Online Comment

Application H16-0717-22
Location 14 Market Place Spalding PE11 2SL
Proposal Creation of 3 self-contained apartments on the first and second floor. Works of repair, restoration and replacement of internal and external features and materials.

Name Greg Watkinson
Address Conservation Officer

Drawing
ALTERED ELEVATION
REAR STORE - EXISTING & PROPOSED
FLAT ROOF ELEVATION - EXISTING & PROPOSED

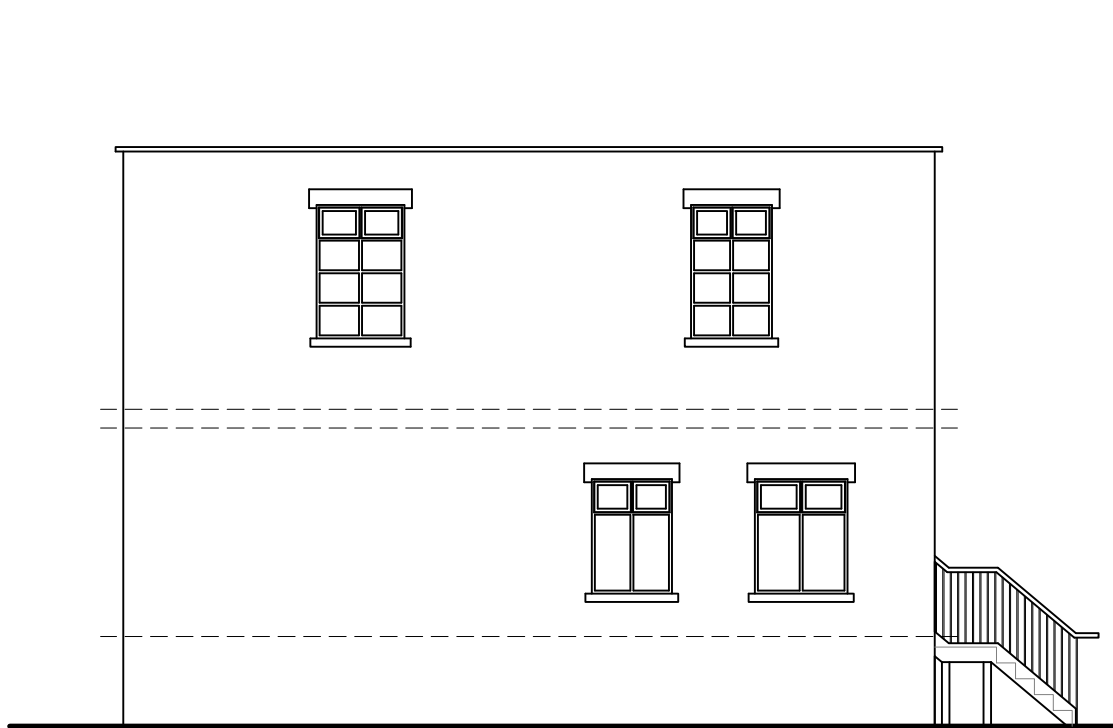
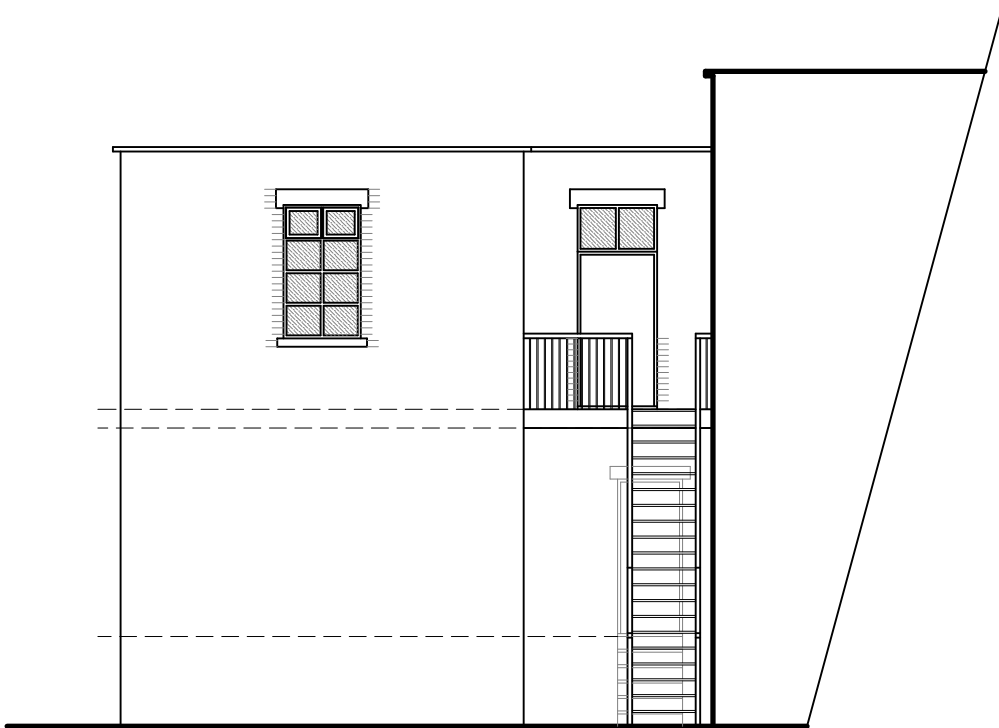
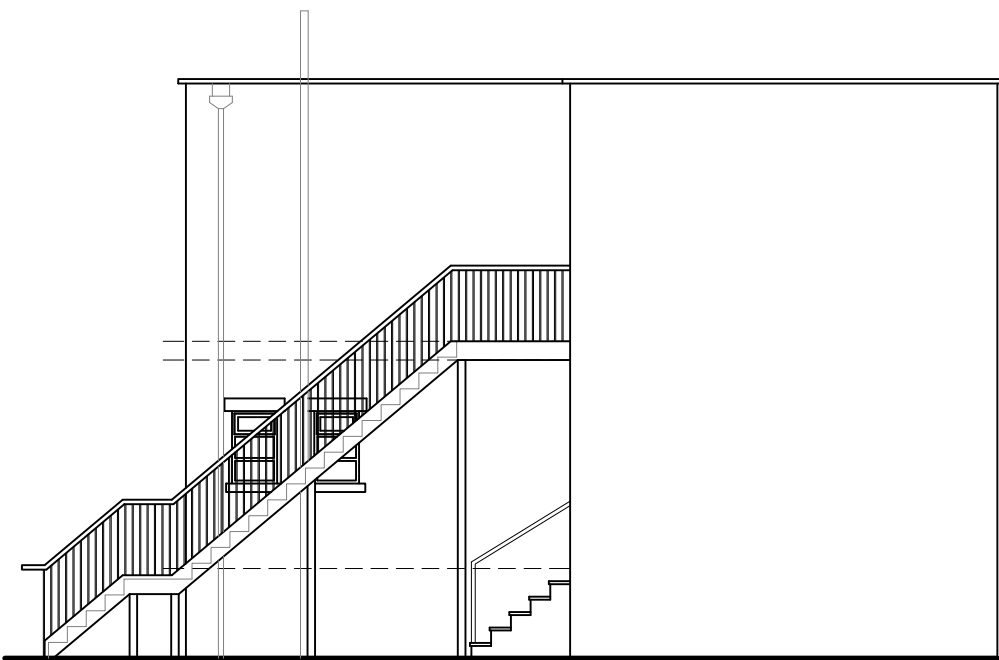
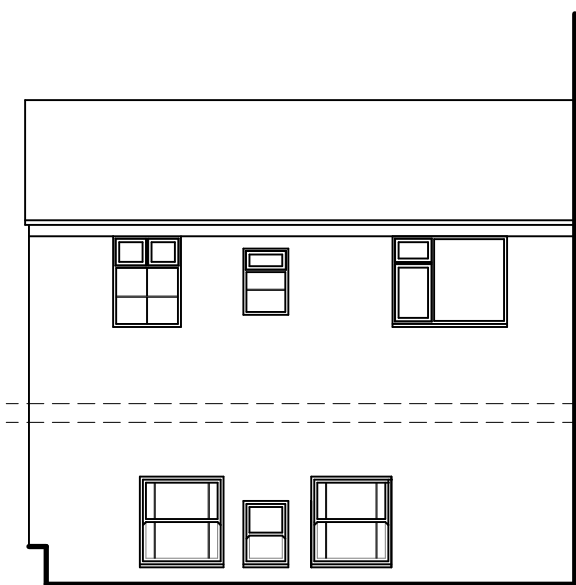
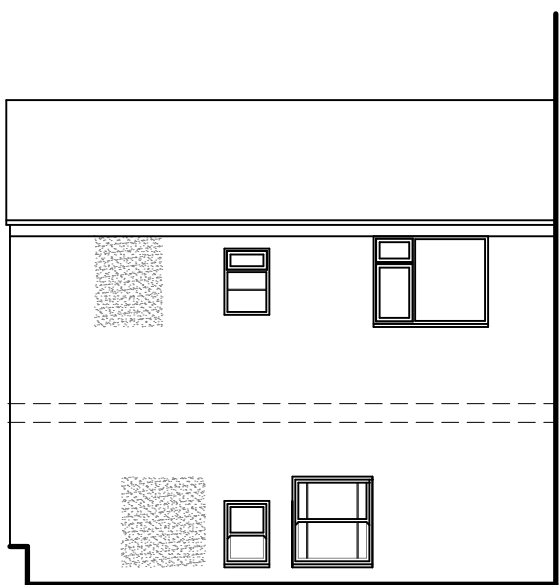
Following the submission of the latest document intended to justify the proposal to install UPVC windows to the rear elevation of this listed building, i write to confirm that i am satisfied with the justification provided and therefore wish to raise no objection to the principle of their installation on the rear elevation of this property.

It should, however, be made clear that under normal circumstances, such a proposal would be absolutely unacceptable and that it is only due to access difficulties and land ownership arrangements that are totally unique to this specific site that it can, in this single instance, be justified in the interest of maintenance. It remains an expectation that all other windows and external accouterments featured on the building should utilize traditional, heritage-appropriate materials.

I would also recommend that the applicant should be required to utilize high-quality wood-effect UPVC windows and that to ensure that this is the case, should the application be approved, it be accompanied with Condition MD13, requiring the submission and approval in writing of details of external windows prior to installation.
